NuPhase, LLC

5930 Paonia Court, Colorado Springs, Colorado 80915

Site Plan

Markup Summary

NuPhase, LLC
5930 Paonia Court, Colorado Springs, Colorado 80915
Site Plan
Nuphase, LLC
87 Seagull Circle, Colorado Springs, Colorado 80921
PHONE (719) 534-0948 FAX (719) 534-0958

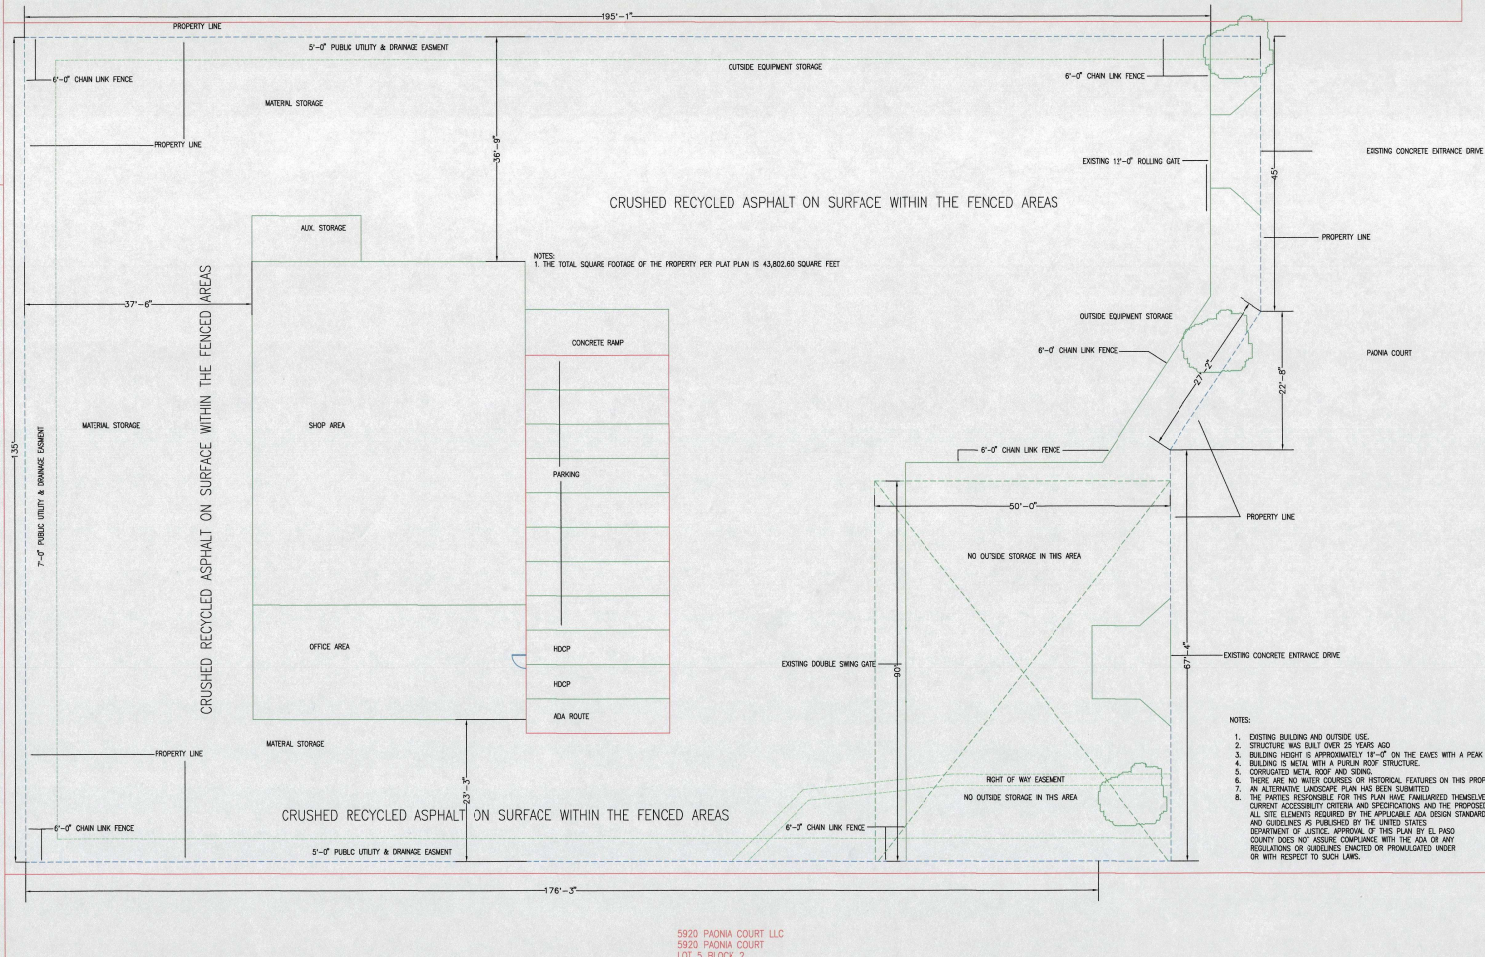
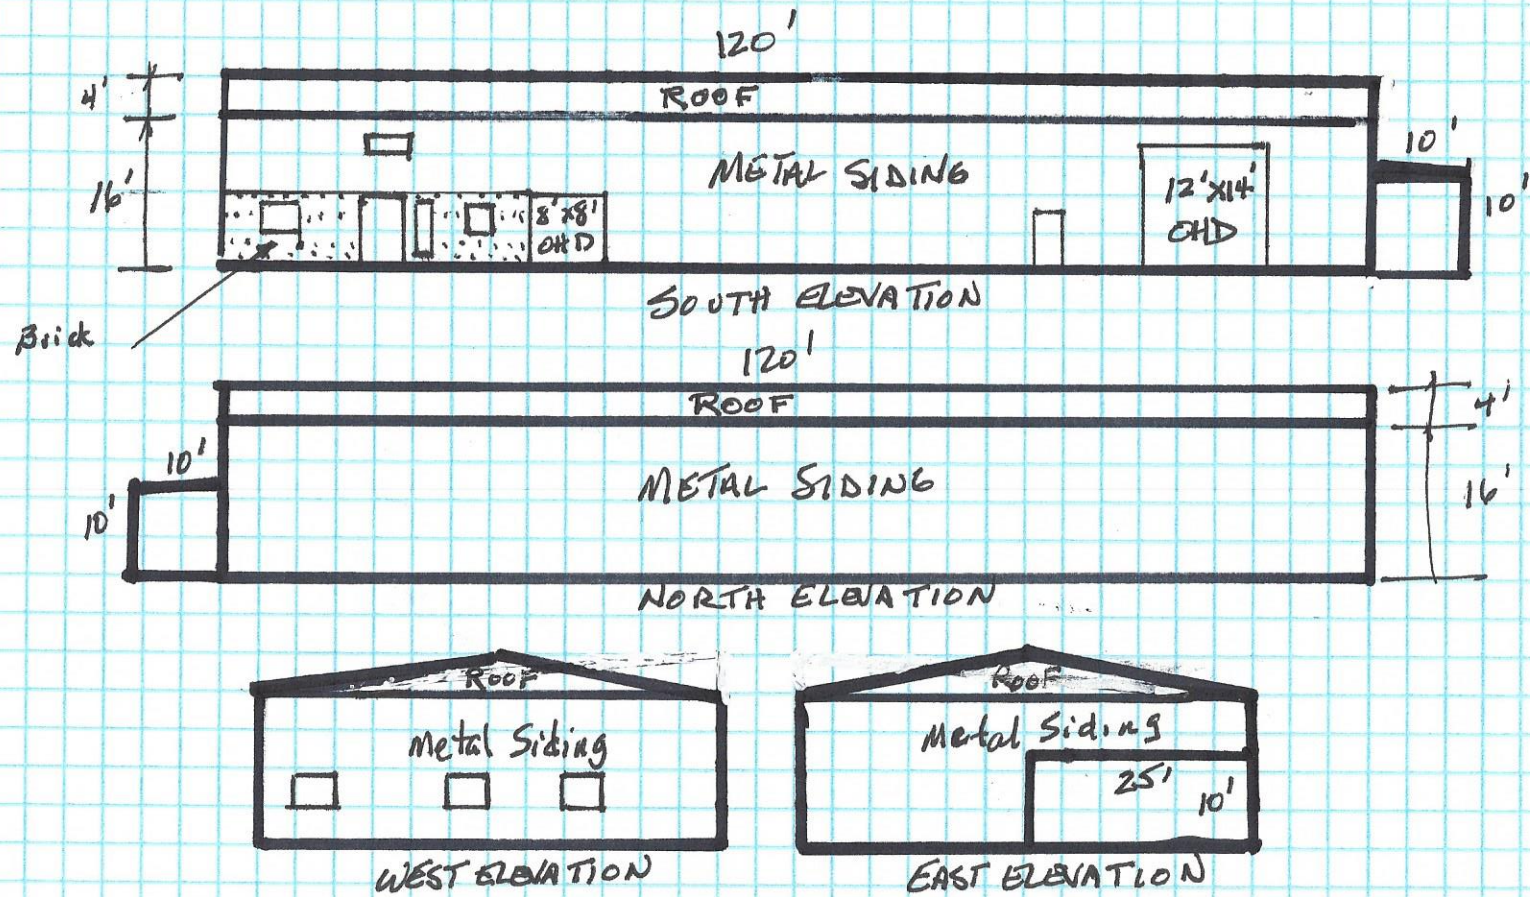
Identify the adjacent property owners. (ie address, owner, parcel ID, etc.)

Clearly identify the property boundary.

Identify the surface type of this area.
